**Baiada Oakburn Poultry Processing Plant (SSD-9394)
EIS Exhibition**

Liz Rogers
Manager, Assessments
DPIE Water – Strategic Relations
23 August 2019

**Baiada Oakburn Poultry Processing Plant (SSD-9394)
EIS Exhibition – Additional Comments**

Figure 4 – Treatment Plan

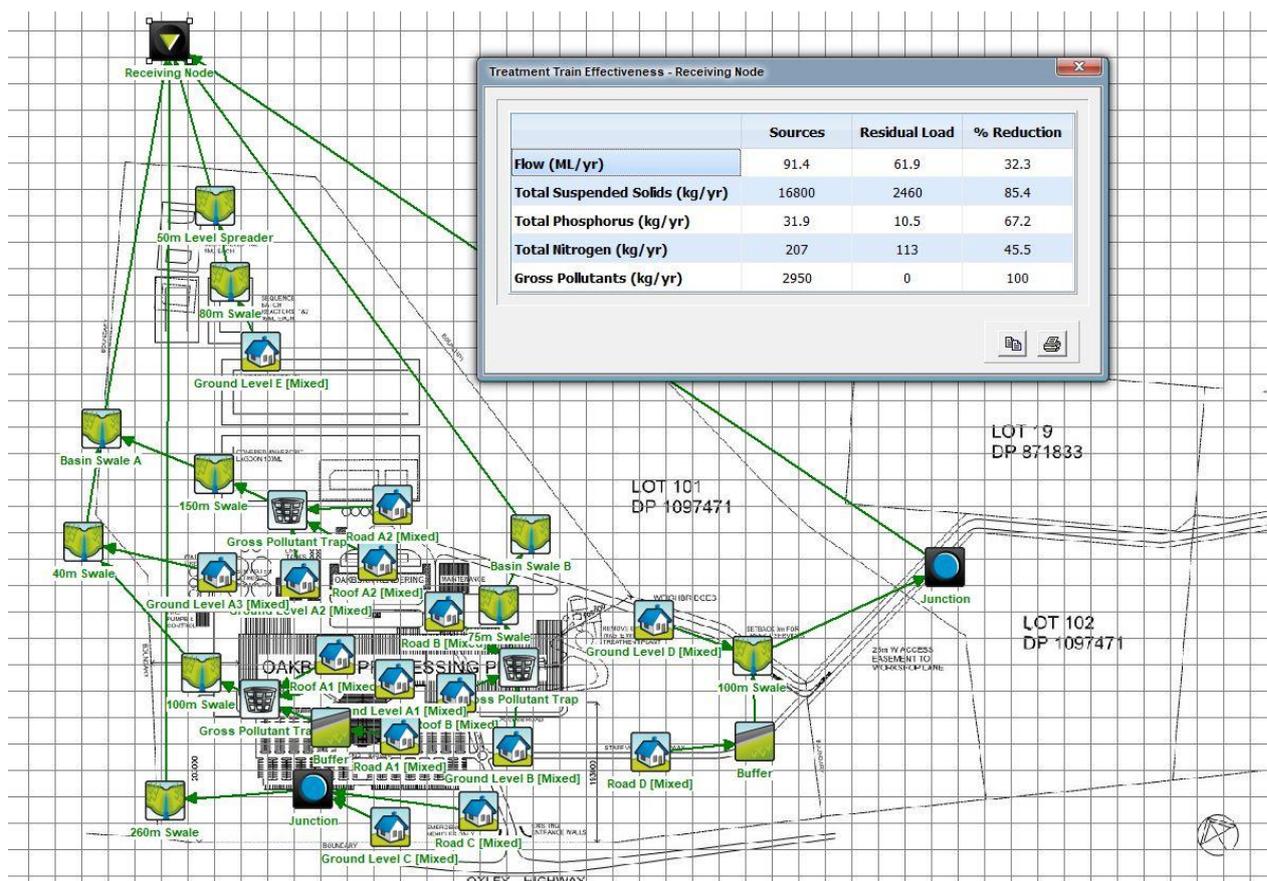
- b. Revision of the size of the retention basins if the reassessment of the storm water rainfall runoff model shows that they are not large enough.
 - c. Undertaking adequate groundwater sampling (e.g. including routine and event based).

The size of the storm water retention basins do not appear to be large enough to contain all the storm water in a 1:100 year event. The model run from 16 August 1958 to 31 December 1992 is not sufficient. It does not include the storm event of 29/11/2008 where 164.2 mm of rain fell in one 24 hr period. The model appears to have only used the rainfall station that closed in 1992 and did not include the new station that commenced in 1993.
